From: Sue Howell
Sent: 09 April 2018 15:50
To: Planning.Responses
Cc: Ross Leal
Subject: RE: Planning Consultation on: AB/4/18/PL

Comment from Greenspace

Registered: 26th January
2018
Site Address: 1-7 Canada Road Arundel BN18 9HZ
Grid Reference: 500889 106965

Description of Works: Demolition of 4 No. existing bungalows &
erection of 5 No. 2 bedroom dwellings with
associated parking & landscape.

Site Plan 1:200

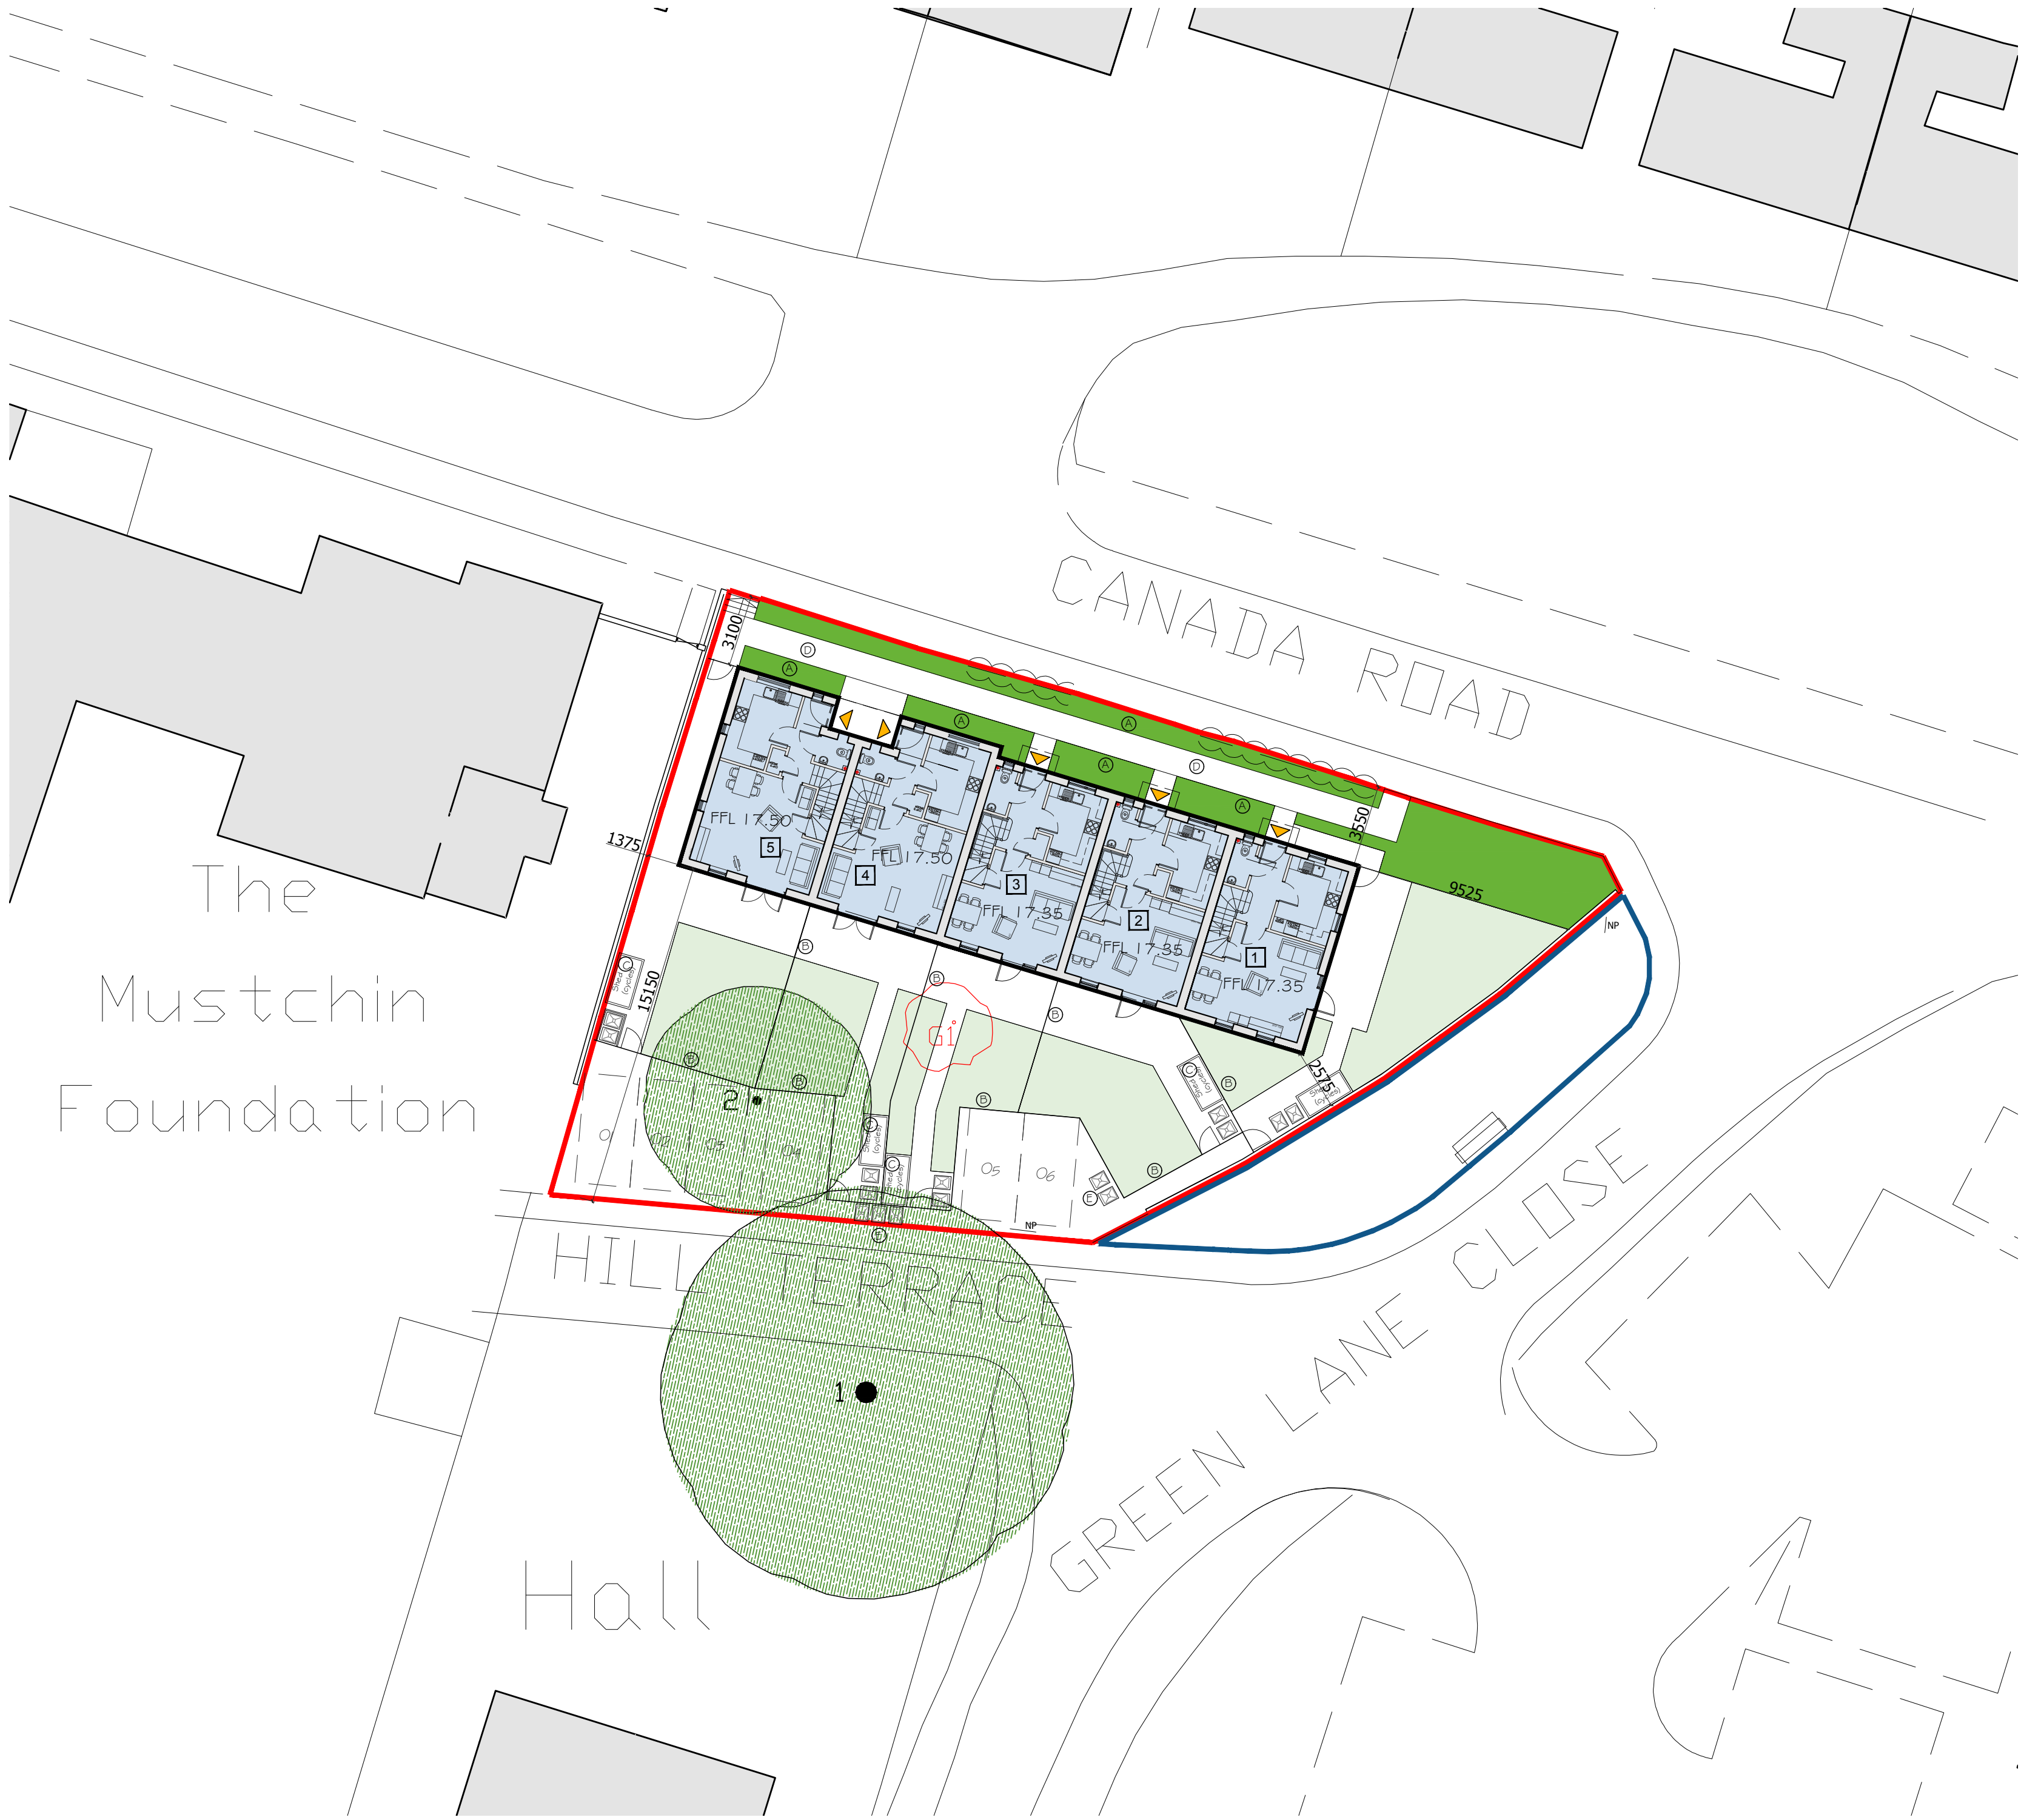
The proposals put forward in this application for the replacement of existing housing will have no perceived landscape impact. The existing landscape features, presently include areas of private garden predominantly laid to lawn with intermittent hedging fronting the residential street of Canada Road. The proposals have allowed for the replacement of this greening to frontage with grass to the side and rear of the development where existing vegetation has been considered and incorporated appropriately. With this being a smaller development of less than 7 dwellings then open space on site is not a consideration. However development of any kind should consider greening to add to the proposal and to enhance the setting. Indicative landscaping has been shown, for this development, a detailed landscape scheme will need to be proposed that will maximise the biodiversity of the site with the inclusion of mixed ornamental and native species for the retention of a variety of habitats. The landscape proposals will need to be shown in plan form detailing species choice, planting densities and size at time of planting.

To be retained existing vegetation, must be protected during construction. There are no tree protection issues associated with this location, the offsite tree to the rear of the proposals is situated out of any root protection areas.

I conclude no landscape objection to the proposals subject to the submission of details above and would recommend that if approved, an early implementation of any new planted areas are to be undertaken within the first season post completion.
